Recommendation Report for Planning Permission for Works or Extension to a Dwelling

REF NO: P/58/21/HH

LOCATION: 21 Barons Mead
Pagham
PO21 4SF

PROPOSAL: Single storey side extension.

Mr. & Mrs. Annis
21 Barons Mead, Pagham
West Sussex PO21 4SF
PROPOSED ELEVATIONS
Date: Dec 2020 Scale 1:100 Dwg.no. PR.EL. 01

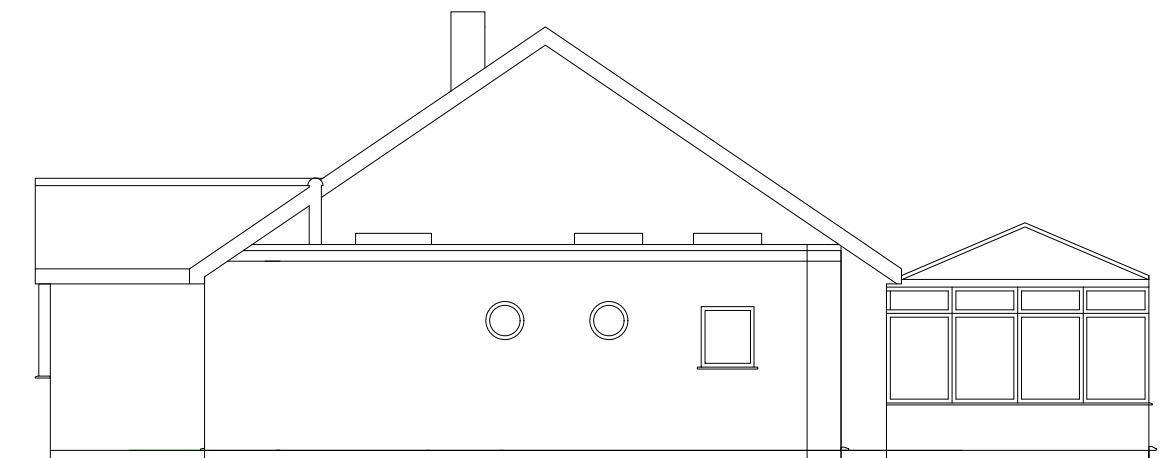
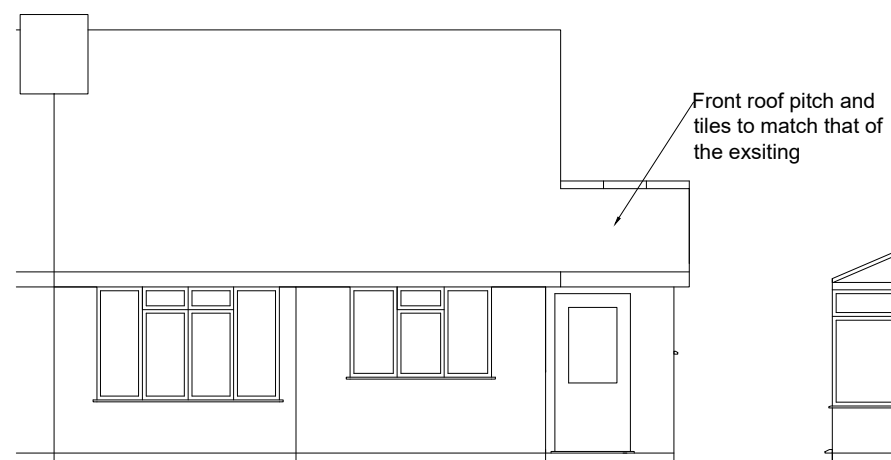
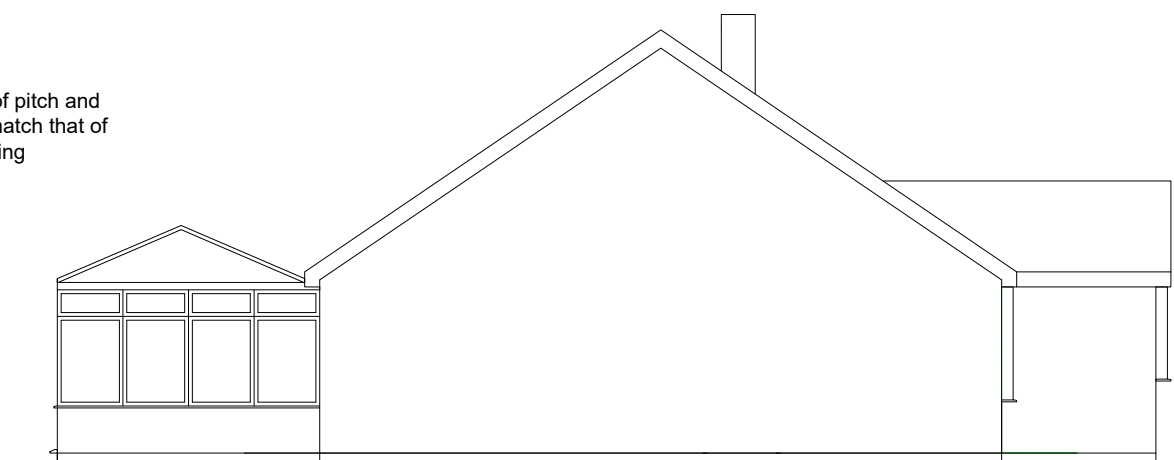
The proposal will have a width of approximately 8.41m and depth of 1.70m. The height to pitched roof will be approximately 3.72m and to flat roof will be approximately 2.86m (3.01m to top of roof light).

There will be a new front door on the east elevation of the extension facing the driveway to east and new door on west elevation facing garden to rear. There will be 2 new rounded port hole windows and 1 square window on northern elevation of extension facing the boundary. There will also be 3 roof lights.

The materials will match existing dwelling and consist of brick walls, pitched roof tiles of plain concrete tiles to match existing pitched roof, G.R.P flat roof materials, and double glazed UPVC windows and doors so comply with policy D DM1 and D DM4 of the Arun Local Plan.

The proposal will have 2 small 'port hole' rounded windows and 1 square window in the north elevation. Whilst these will increase risk of overlooking to neighbouring property number 23, it will not cause adverse harm to overlooking due to the small size of port hole windows and the position of the windows leaving 0.70m gap remaining to northern boundary so will reduce effects of overlooking to neighbouring property number 23 to north.

Mr. & Mrs. Annis
21 Barons Mead, Pagham
West Sussex PO21 4SF
SITE PLAN
Date: Dec 2020 Scale 1:100 Dwg.no SP. 01

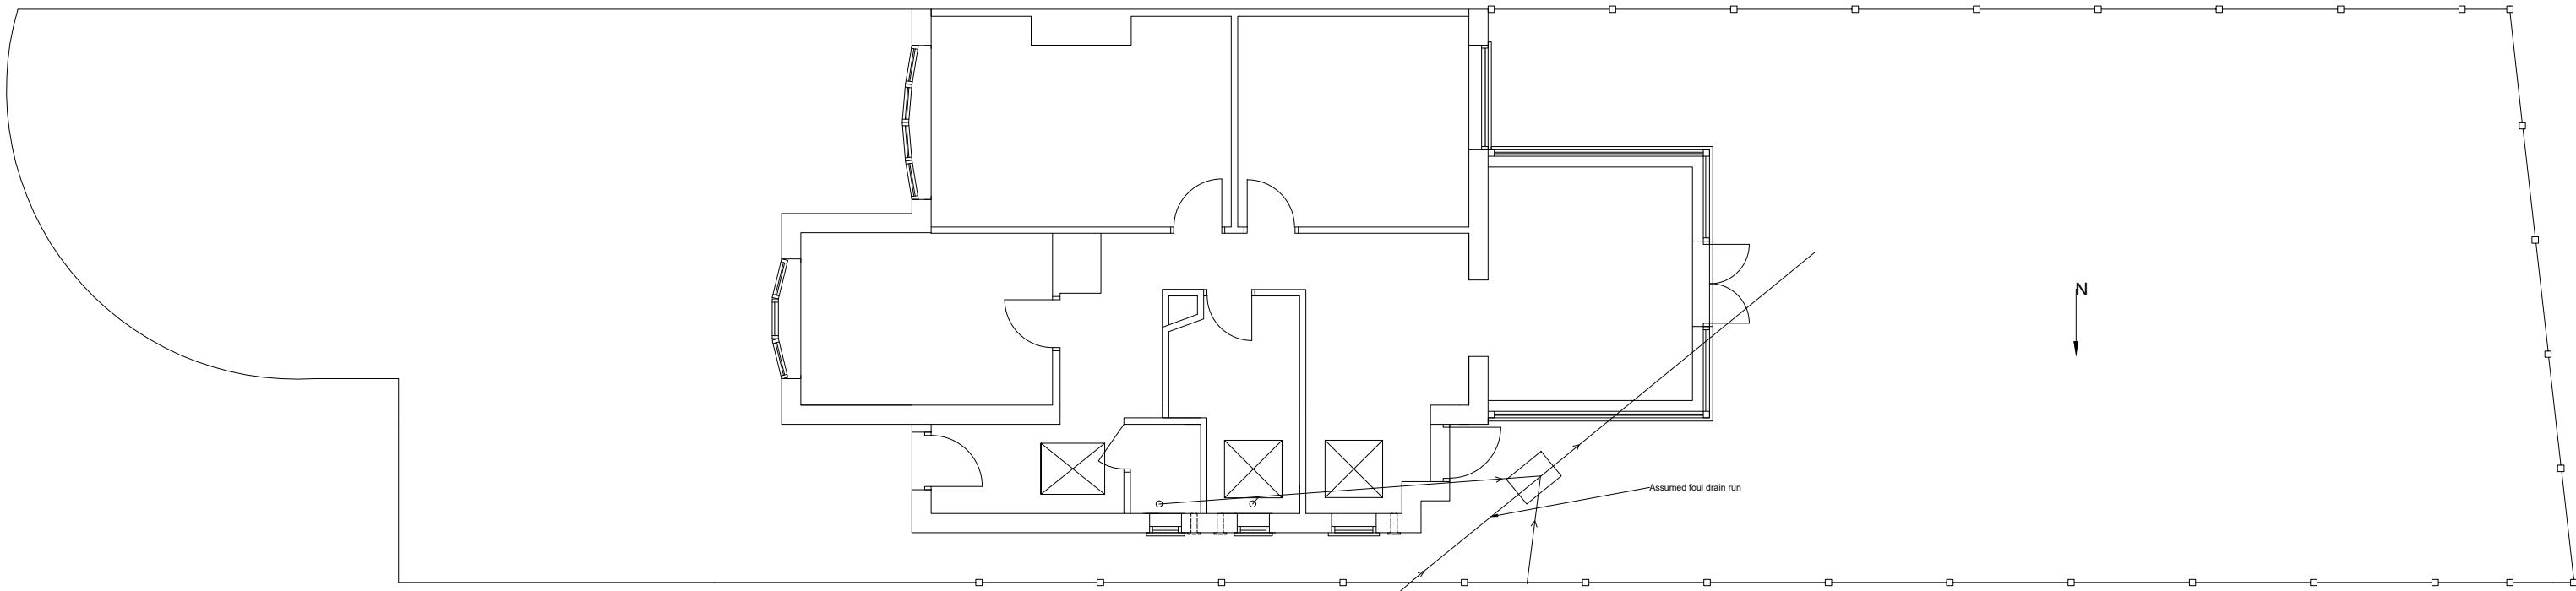
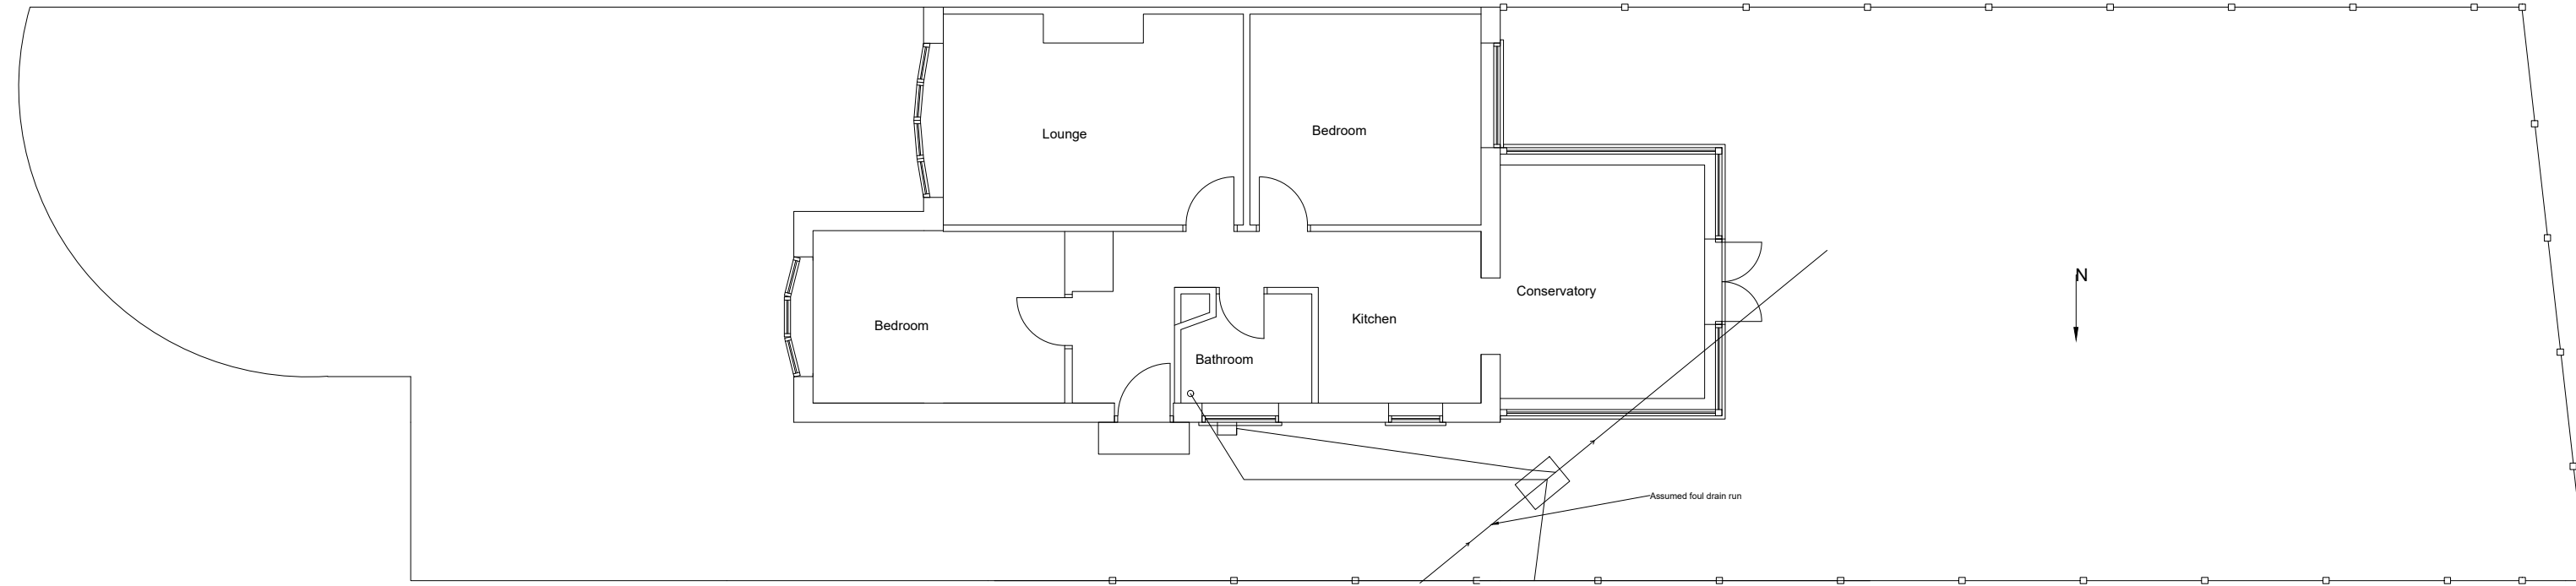
The proposals are for a single storey side extension to north elevation. The extension will part infill the north elevation of property to leave 2.03m remaining to front principal elevation (east) and 4.14m remaining to rear principal elevation (west). There is around 0.80m remaining to northern boundary fence. The proposal will have a pitched roof at the front (east) and a flat roof behind along part of north elevation. The roof design is visually integrates with the property so complies with policy D DM4 of the Arun Local Plan.

Arun recently adopted a Design Guide. It states development should be subservient to the main property and this complies in terms of scale and size. It also states in streets characterised by small gaps between buildings, extensions must not close important gaps in the street scene by leading to a terracing effect, or remove existing external access from front to back gardens. Whilst the proposals being within 1m of north side boundary do not comply, there is a gap of around 0.70m remaining to boundary so this is acceptable.
